Issue Specific Hearing 1 (ISH1) General and overarching matters

Hearing Action Points

Application by Elements Green Trent Limited for an Order Granting Development Consent for the Great North Road Solar and Biodiversity Park (EN010162).

Actions arising from **ISH1** held on **Wednesday 26 November and Thursday 27 November 2025**

Cumulative Applications Figure A2.1.1

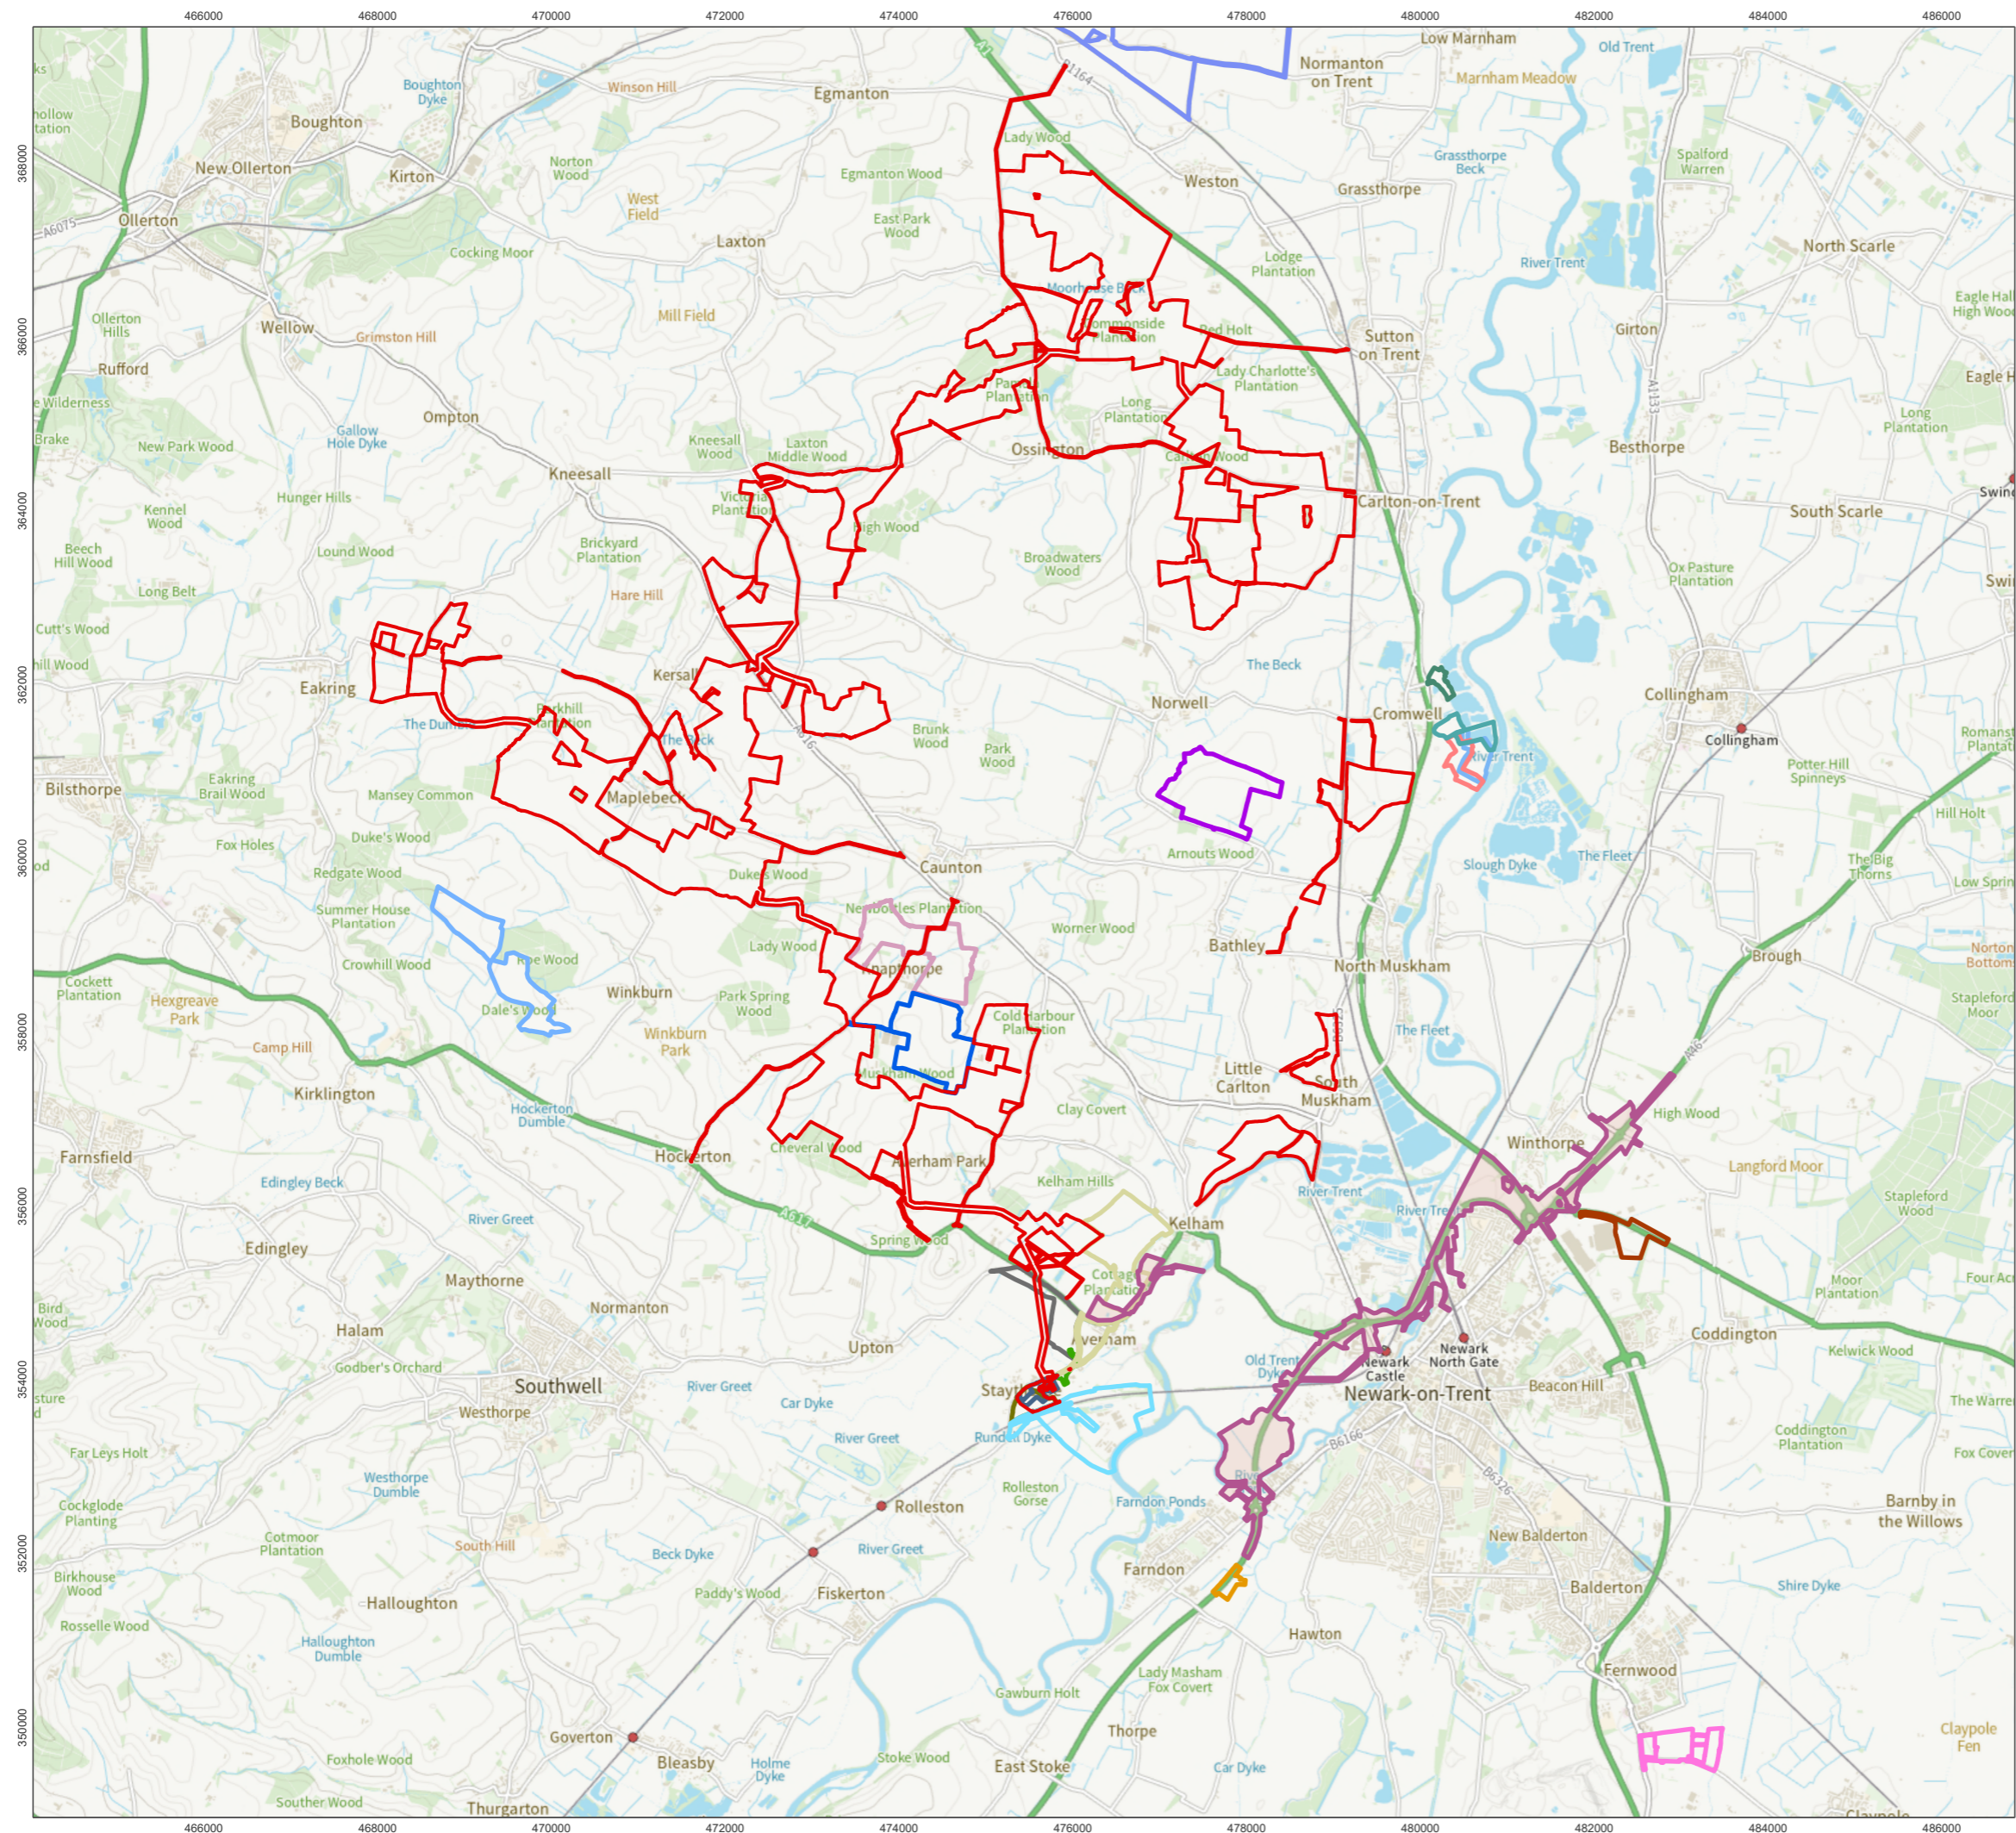
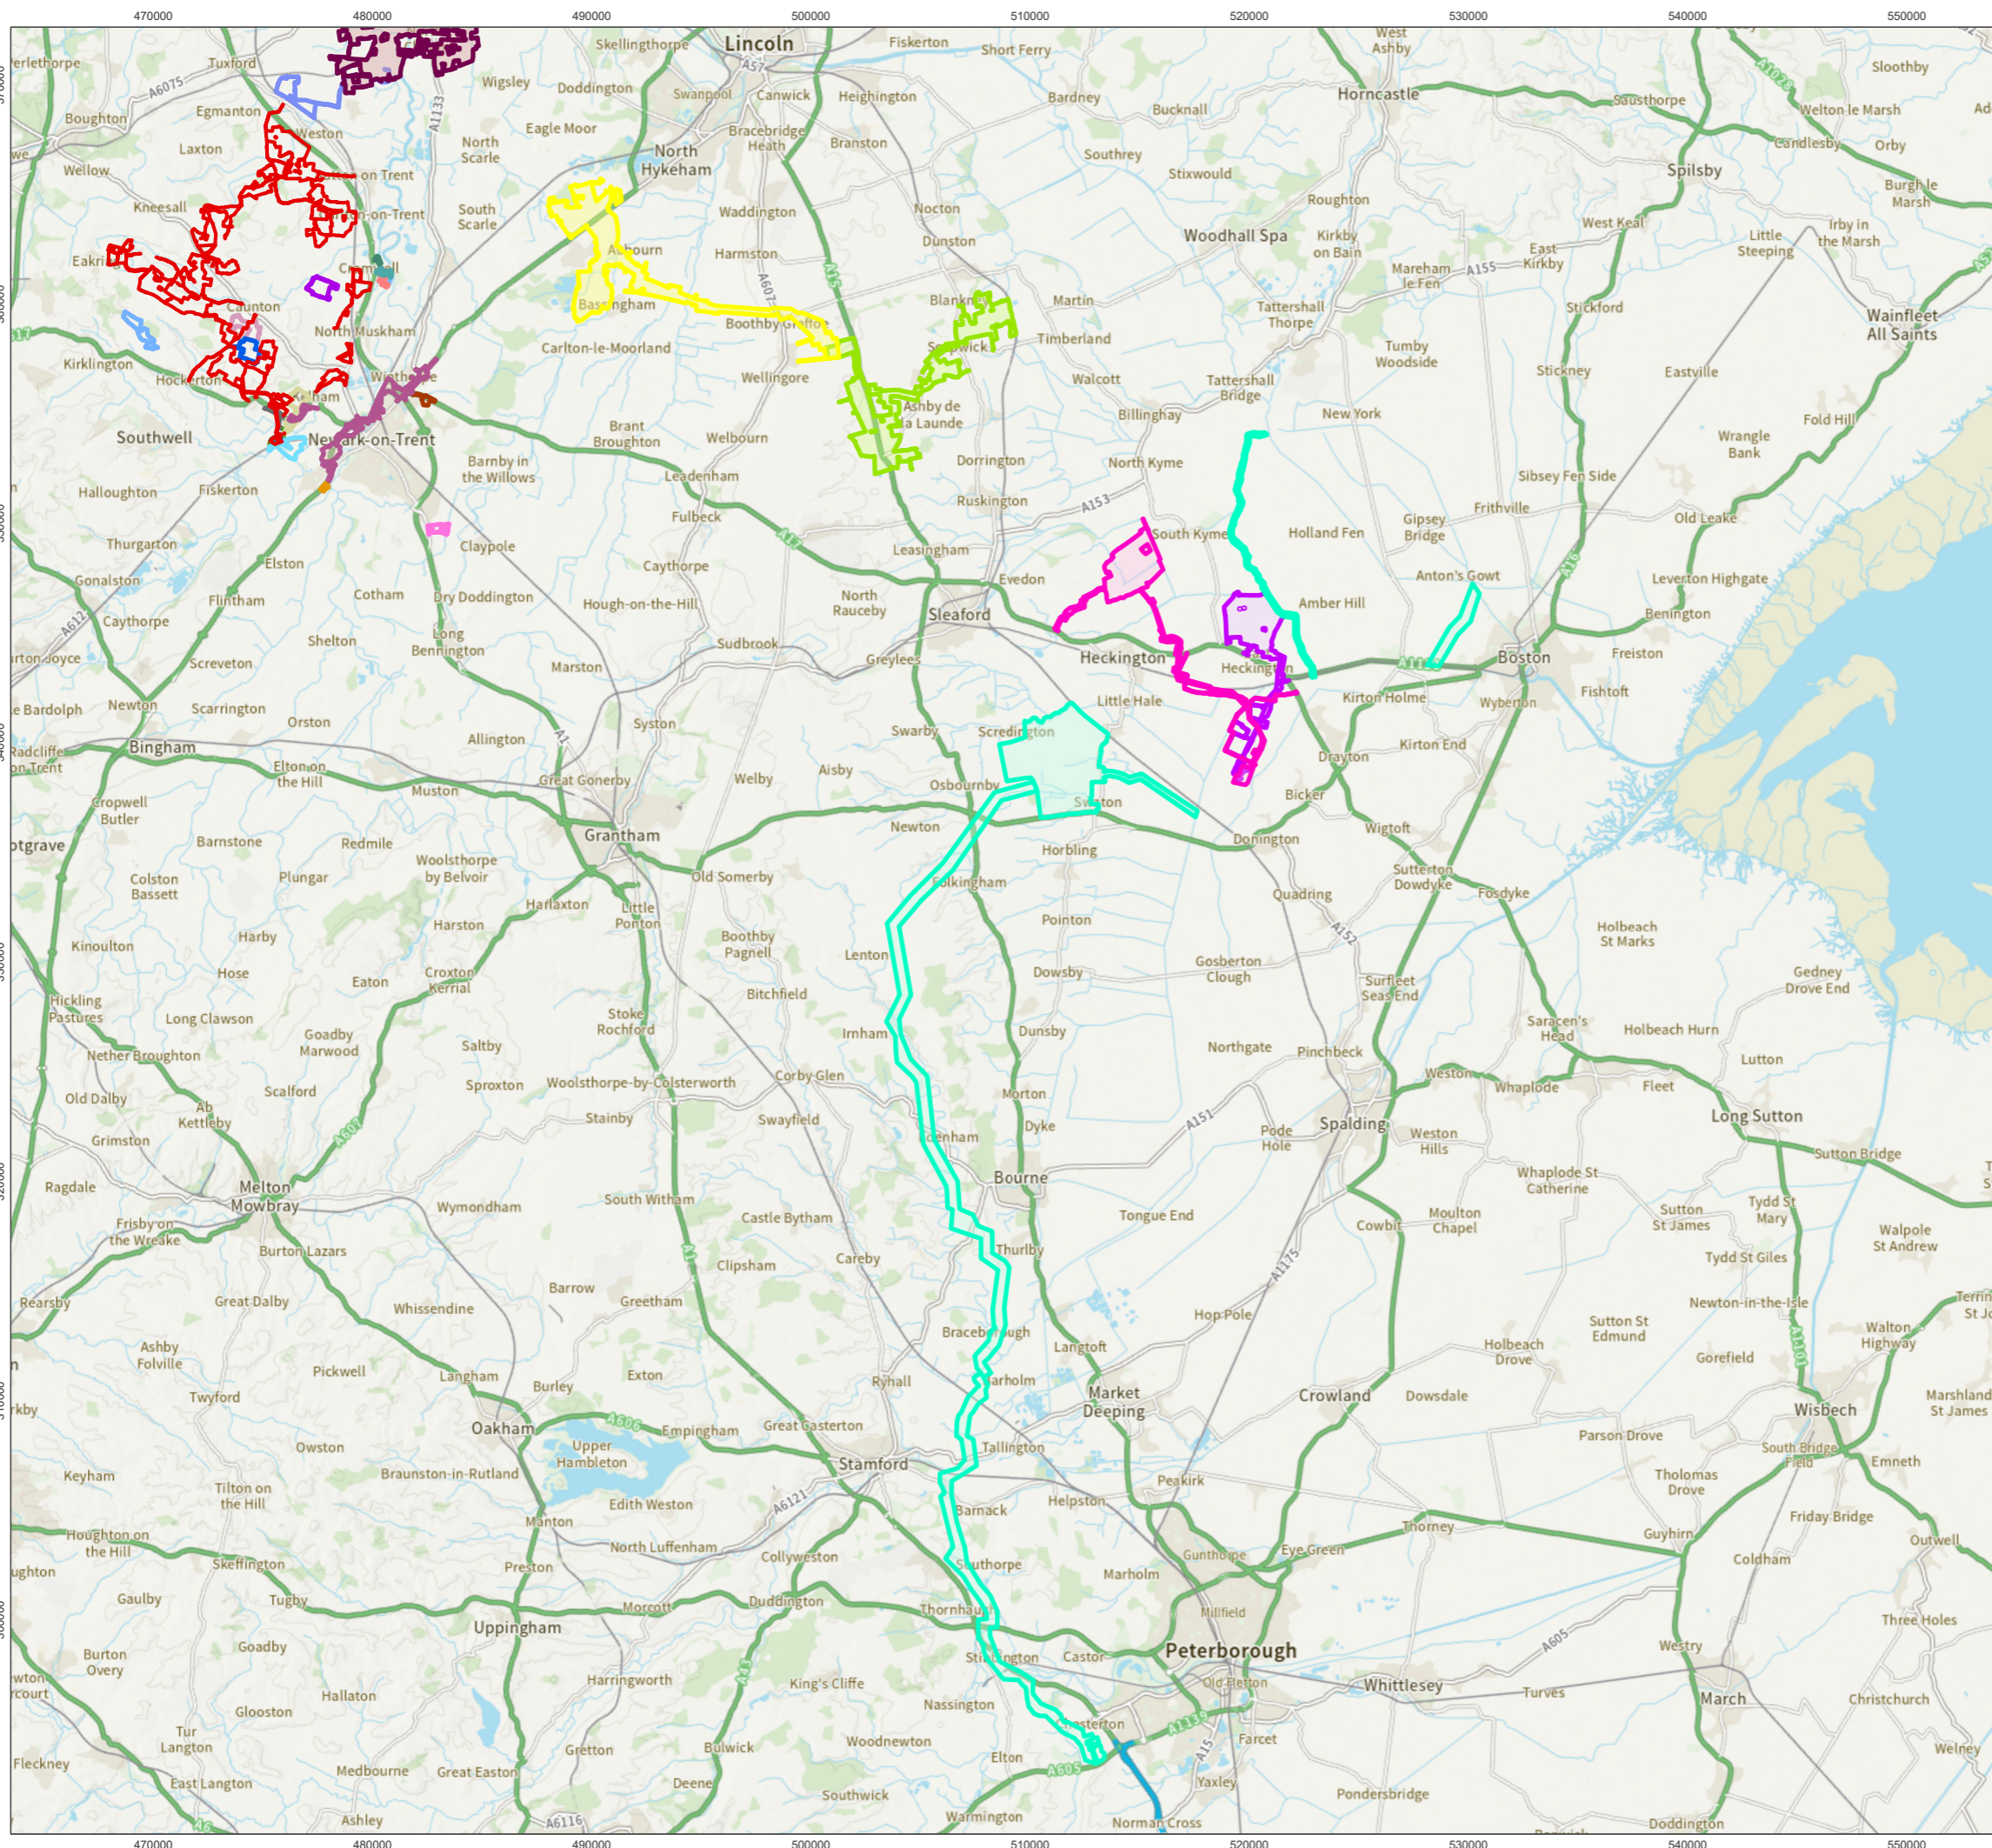
17.	Please review Technical Appendix A2.1 – Cumulative Assessment Stages 1 and 2 [APP-191] at Figure A2.1.1 (a-d), noting that there is some confusion as projects are not listed by names but rather their reference numbers, which are not all up to date (eg the Steeple Renewables DCO application appears to have its scoping report reference)	Applicant	D1
